The Planning Inspectorate

A46 Newark Bypass – Development Consent Order Application

A46 from Farndon Roundabout to Winthorpe Roundabout, near Newark-On-Trent

Deadline 3 (26 November 2024)

**Figure 3 - Farndon West and Farndon East FCA's. Source: Environmental Masterplan [AS-026]**

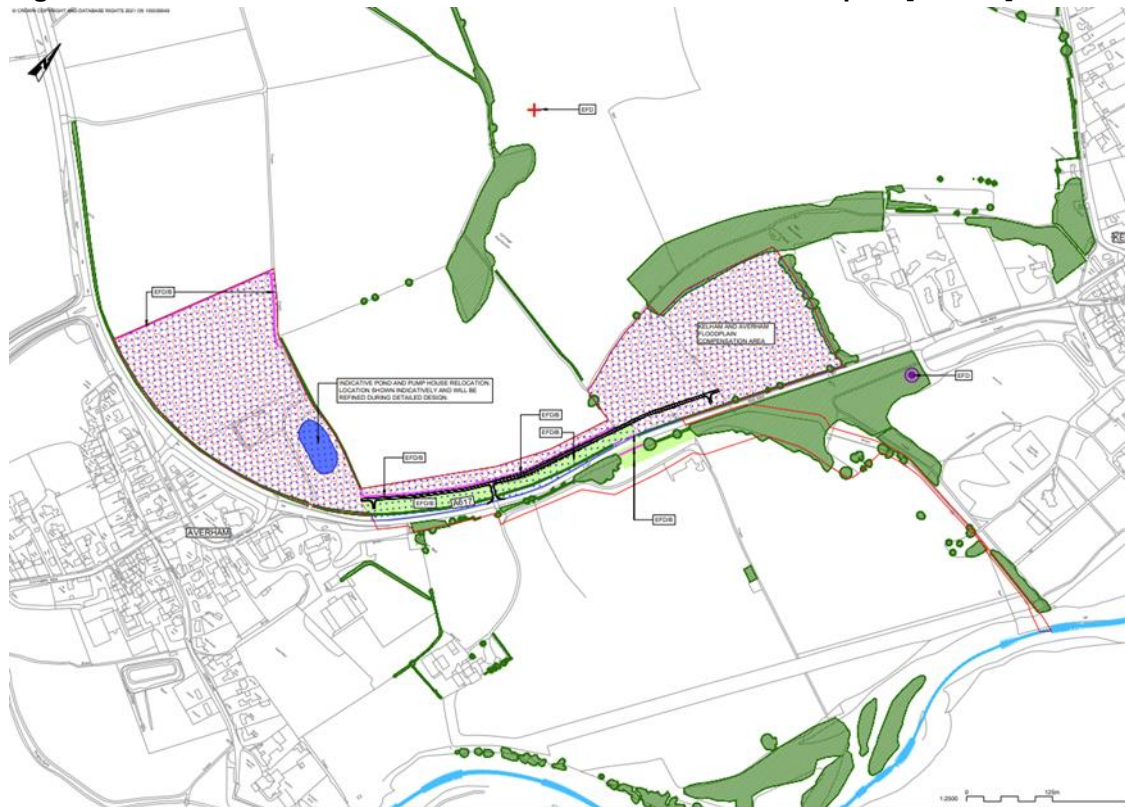
We note the Applicant's response to this question. The Applicant needs to add this detail to the FCA Technical Note they have provided to the Environment Agency (on 15 October 2024) for review outside of the Examination process, as this currently has no reference to the any of the FCAs being used to store surface water and additional water from the Old Trent Dyke
